PLANNING APPLICATION CONSULTATION RESPONSE

Application Number:	3/2023/0263
Proposal:	Construction of 15 eco lodges and infrastructure to provide additional accommodation for Eaves Hall (pursuant to variation of conditions 2 (Plans), 3 (Materials), 4 (Landscaping), 5 (Refuse/Cycle Store), 12 (Landscaping Scheme), 14 (Drainage Scheme), 15 (Surface Water Pollution), 16 (Surface Water Ponds), 19 (Construction Method Statement) and 22 (Bird/Bat Boxes) of planning permission 3/2020/0544) to reflect updated layout and change of lodge type and additional technical details submitted.
Location:	Eaves Hall Moor Lane West Bradford BB7 3JG

Lead Local Flood Authority Position

1 Proposed Site Plan
Scale: 1:500

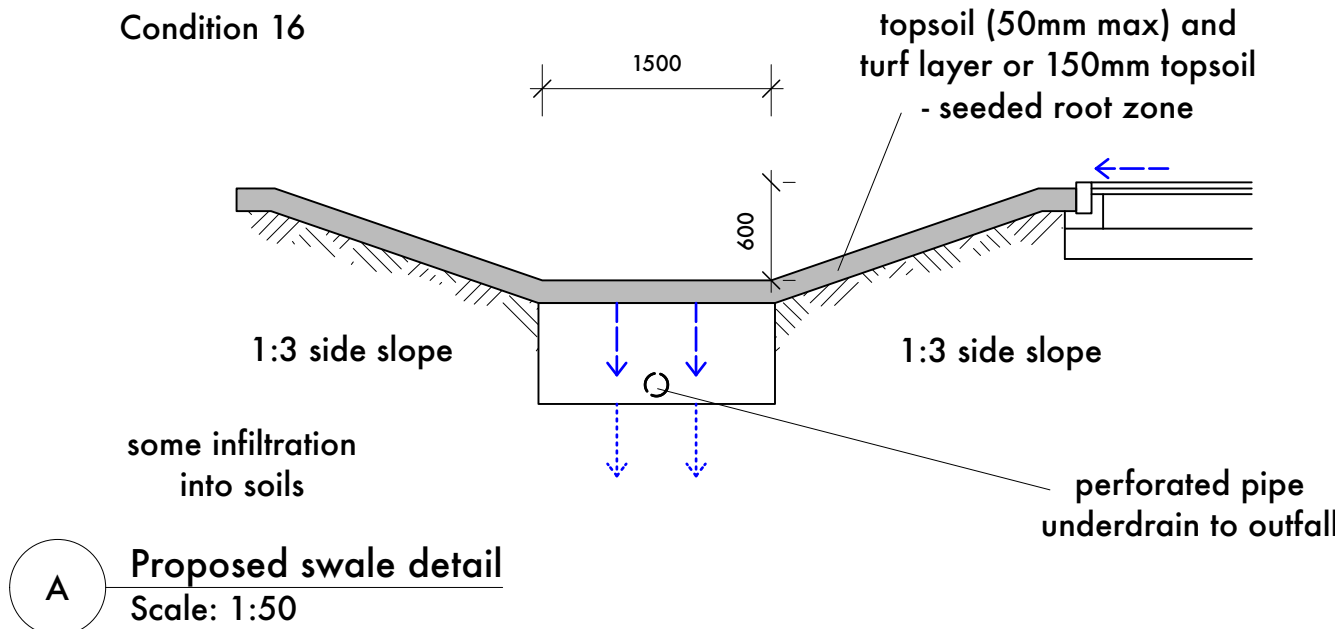
- The applicant has failed to provide details of 'a final surface water drainage layout plan; appropriately labelled to include all pipe/structure references, dimensions, design levels, finished floor levels and external ground levels'.
- The applicant has failed to provide an appropriate flood water exceedance route plan, the plan should cover the whole site.
- The applicant has failed to provide evidence of a site plan showing areas that contribute to proposed surface water drainage network.
